TECHNICAL DATA SHEET
 PETITION NO. 98-97 FOR PUBLIC HEARING

CHARLOTTE - MECKLENBURG PLANNING COMMISSION
INTER - OFFICE COMMUNICATION

SUBJECT: Administrative Approval for Petition No. 98-97 by Childress Klein Properties, Inc. Tax parcels 123-041-14, 123-041-15-21 and 123-041-23.

TECHNICAL DATA SHEET
 PETITION NO. 98-97 FOR PUBLIC HEARING

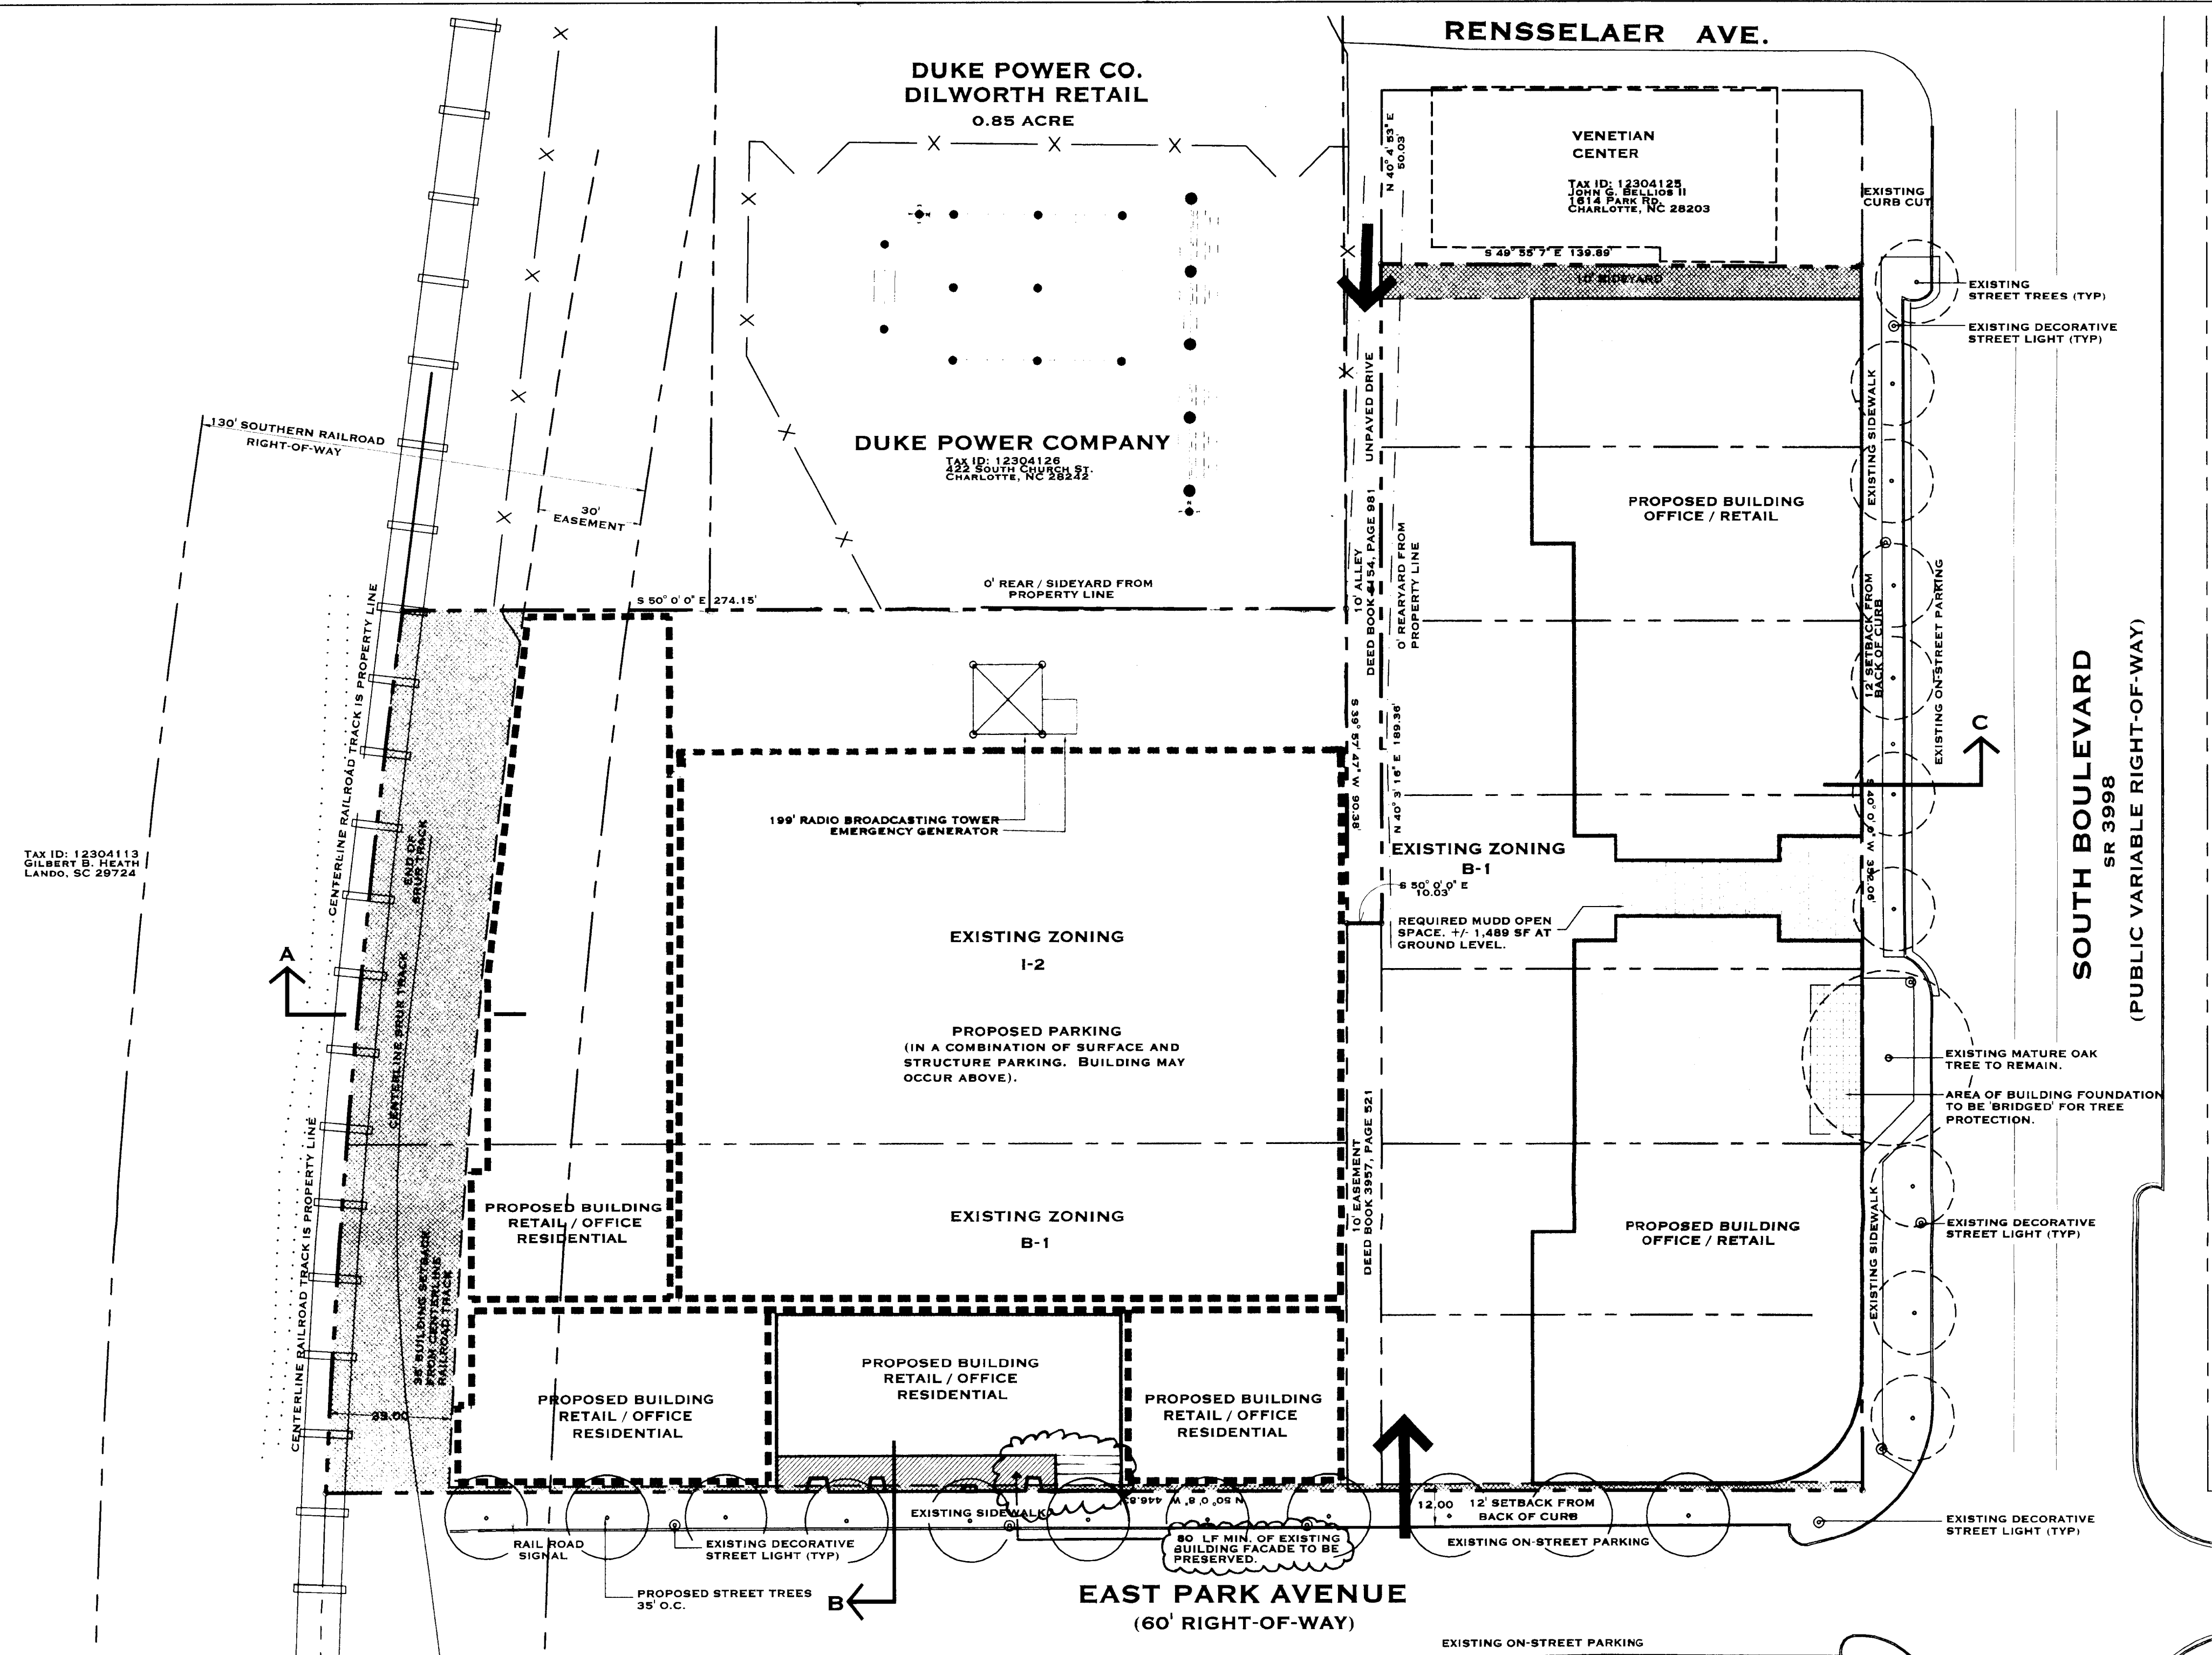
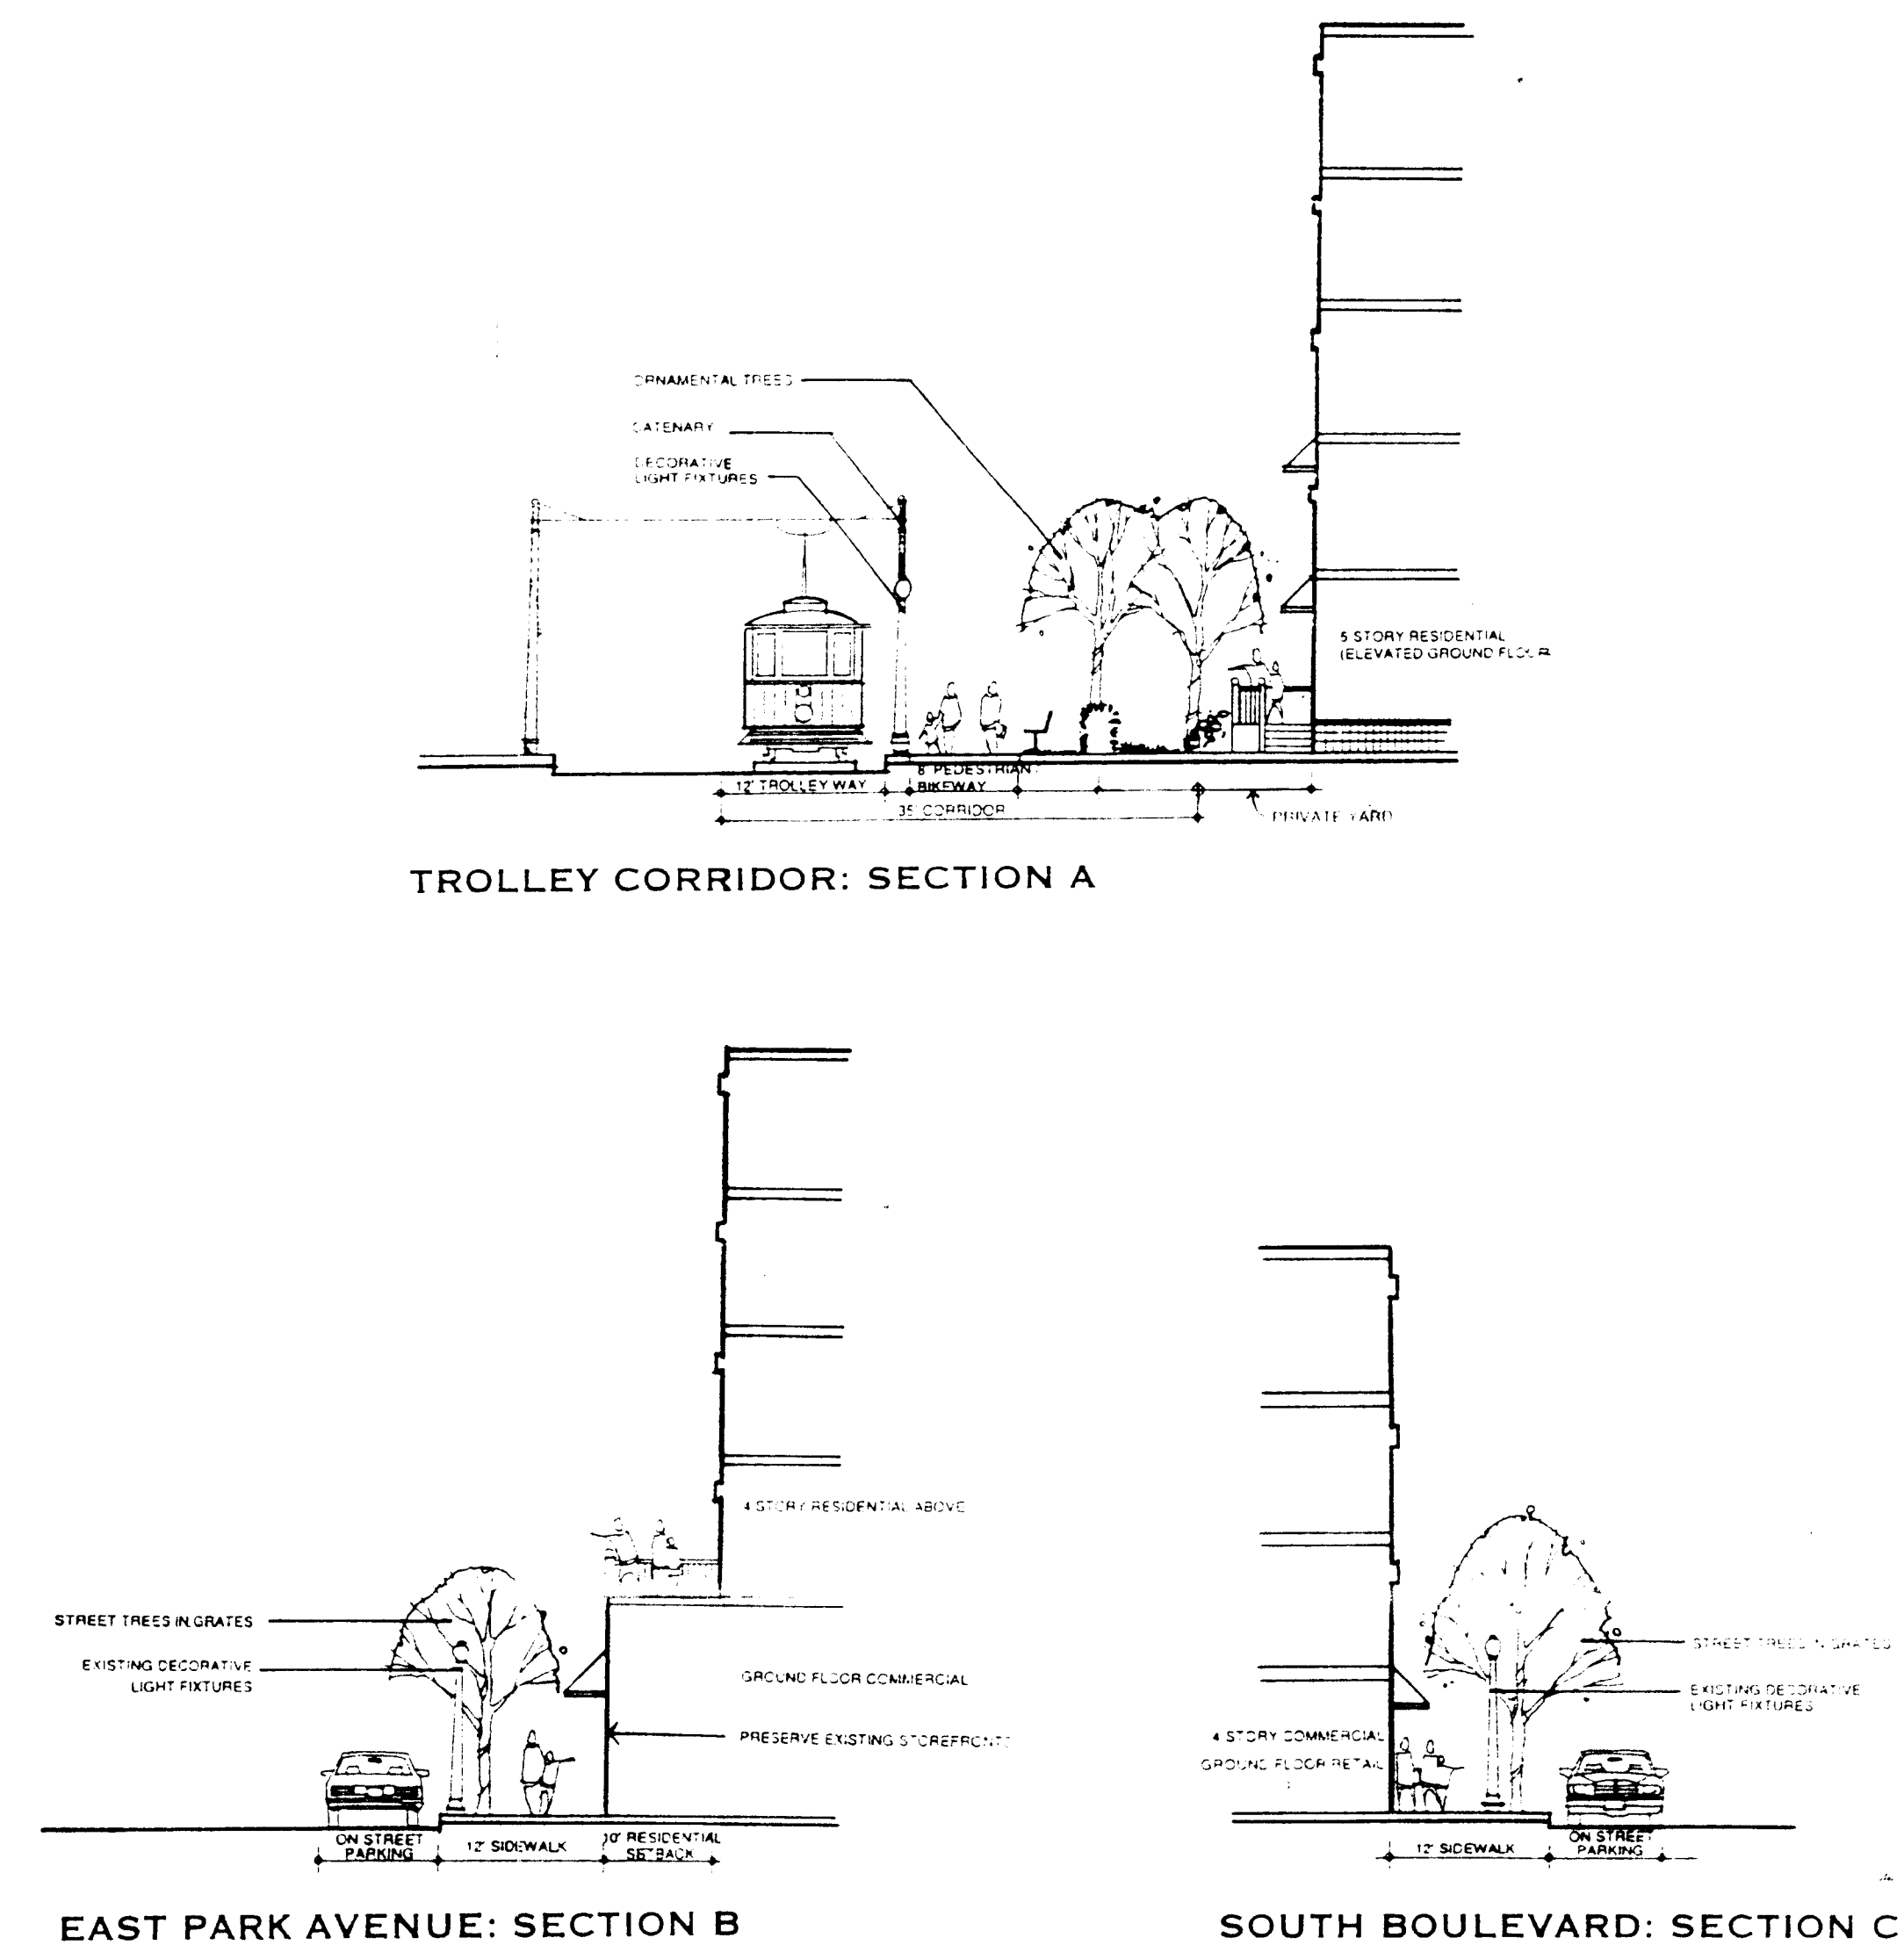
Attached is a copy of the revised plan for the above rezoning petition. The plan has been revised to reduce the amount of building facade that will be preserved along East Park Avenue from 100 feet, to 80 feet. Since this change is minor and does not alter the intent of the development, I am administratively approving this revised plan. Please use this revised plan when evaluating request for building permits and certificates of occupancy.
